21 December 2018

Maryvale Solar Farm - SSD 8777

Property: 'Waroona' 121 Maryvale Road & 'Scarborough House' 801 Cobbora Road, Maryvale, Lot 2 DP 573426, Lots 1 & 2 DP 1095725, Lot 1 DP 1006557, Lots 122 & 182 DP 754318, 87 Maryvale Road, Maryvale.

# APPENDIX 3: SUBDIVISION PLAN

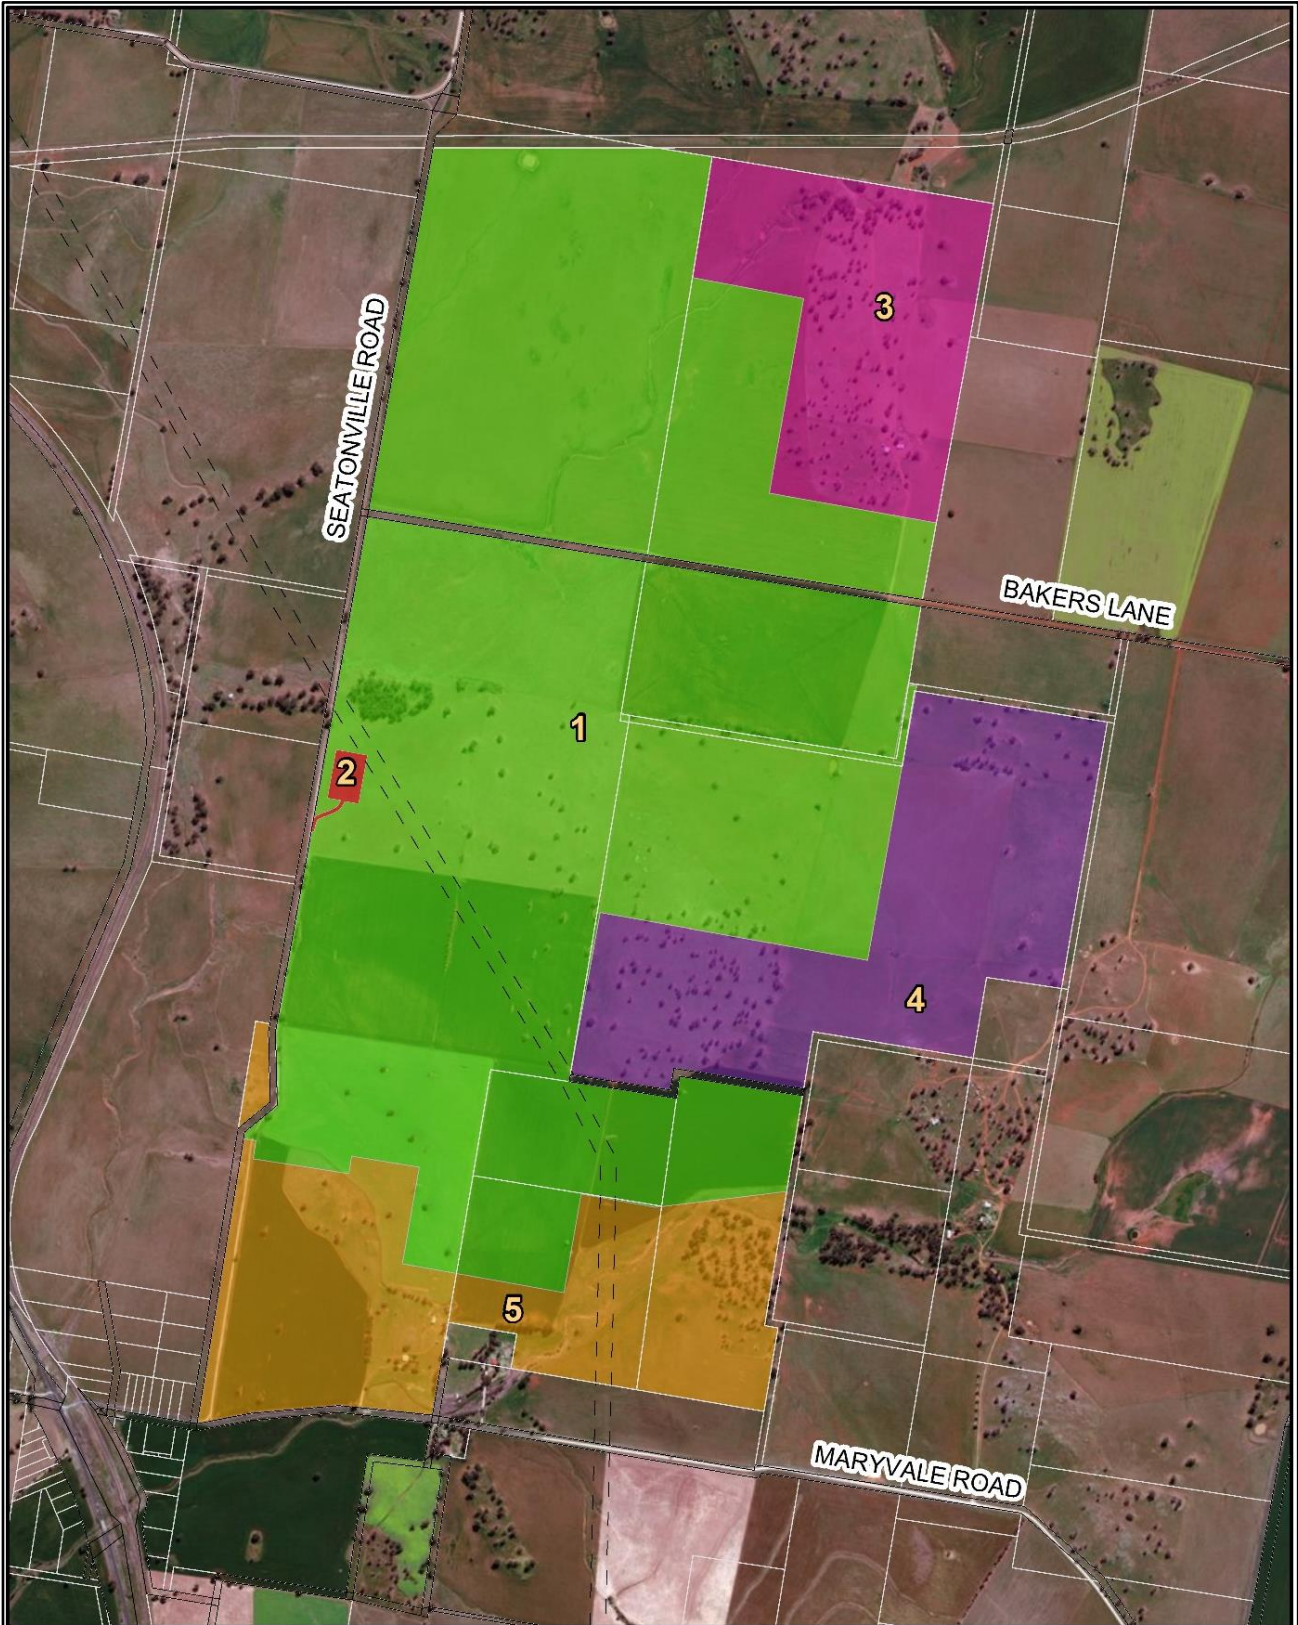
The EIS section 5.6.1 Wellington Local Environmental Plan (2012) discusses the proposed subdivision of the site, which will involve 'lease lots' as per Figure 5-1 (see above). The description of the proposed new lots does not match Figure 5-1, containing the following errors:

- Proposed Lot 1 includes Pt Lot 1 DP 1095725 & Pt Lot 2 DP 1095725; and
- Proposed Lot 4 is stated as being 64 ha, when Figure 5-1 states 84 ha.
